Planning application for conversion of a single dwelling house into six flats

75 Highfield Road Bognor Regis - BR/215/18/PL

I object to the above application on the following grounds.

Second Floor Plan (Proposed) @ 1:100

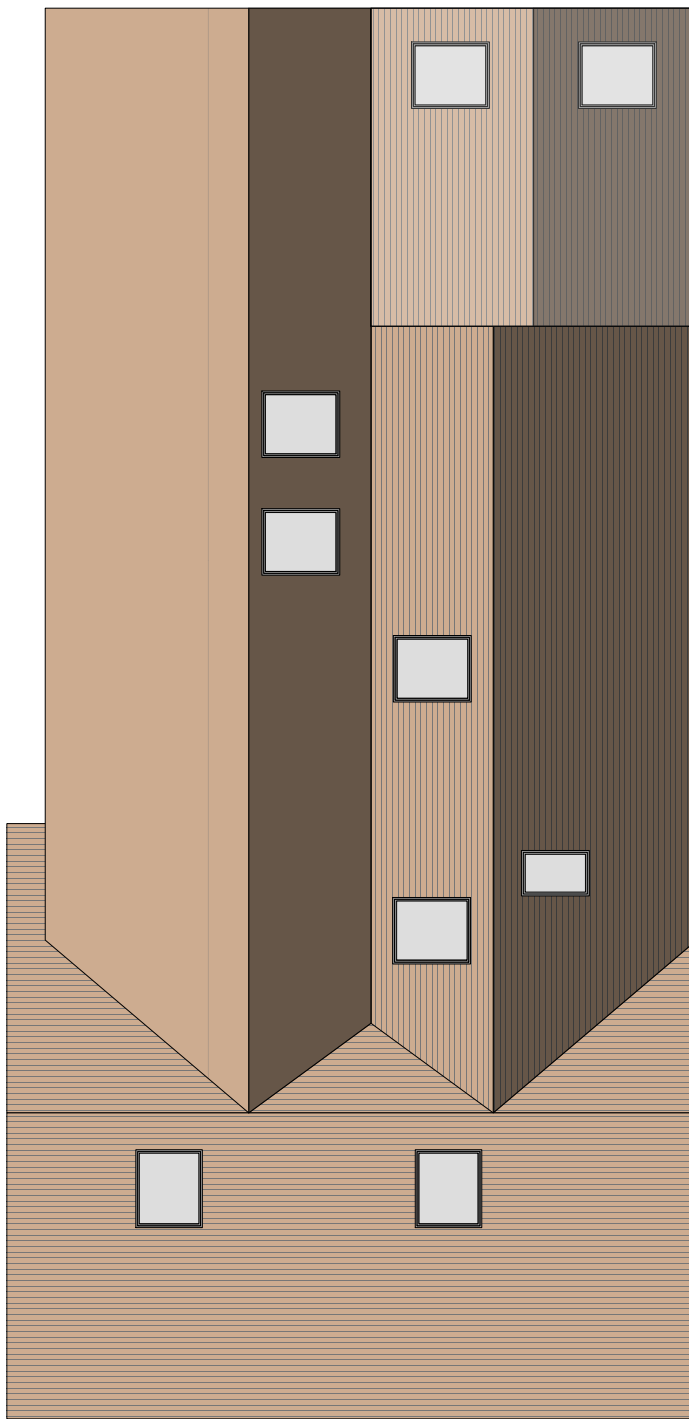
The owner of No 69 has quite properly objected to overlooking; policy on this has become onerous and will no doubt result in primary upper floor rooms with obscure glazing and inadequate ventilation even where that is not necessary, this will create quite Dickensian accommodation which should not be acceptable a century and a half later. This may have already started as I note one Second Floor bedroom shown without window or rooflight.

Site Plan (Proposed) 1:200

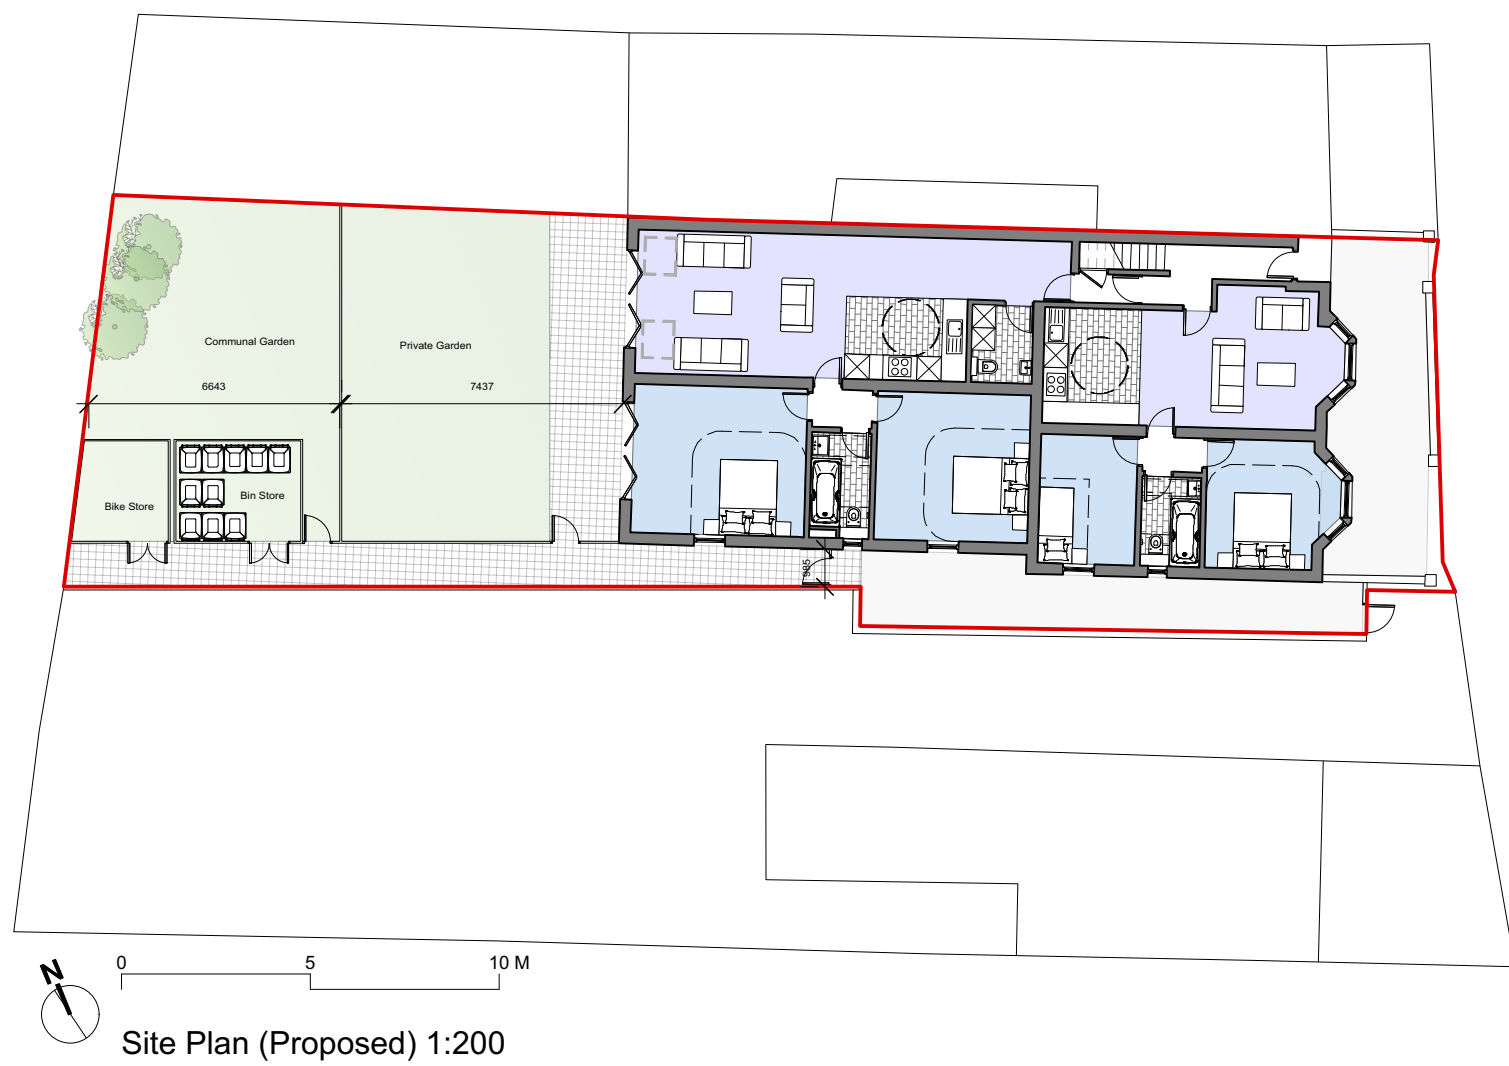
The existing house does just about have two on-site vehicle spaces and thus has a neutral effect. Based upon the adopted parking standard, the flats with the habitable rooms as shown, would demand 10 spaces; this being a maximum to be reduced if justifiable. The standard states that those spaces are to be provided within the layout near to the dwellings.

A more modest considered development could easily provide adequate parking on site at the rear and provide space for contractors during the build.
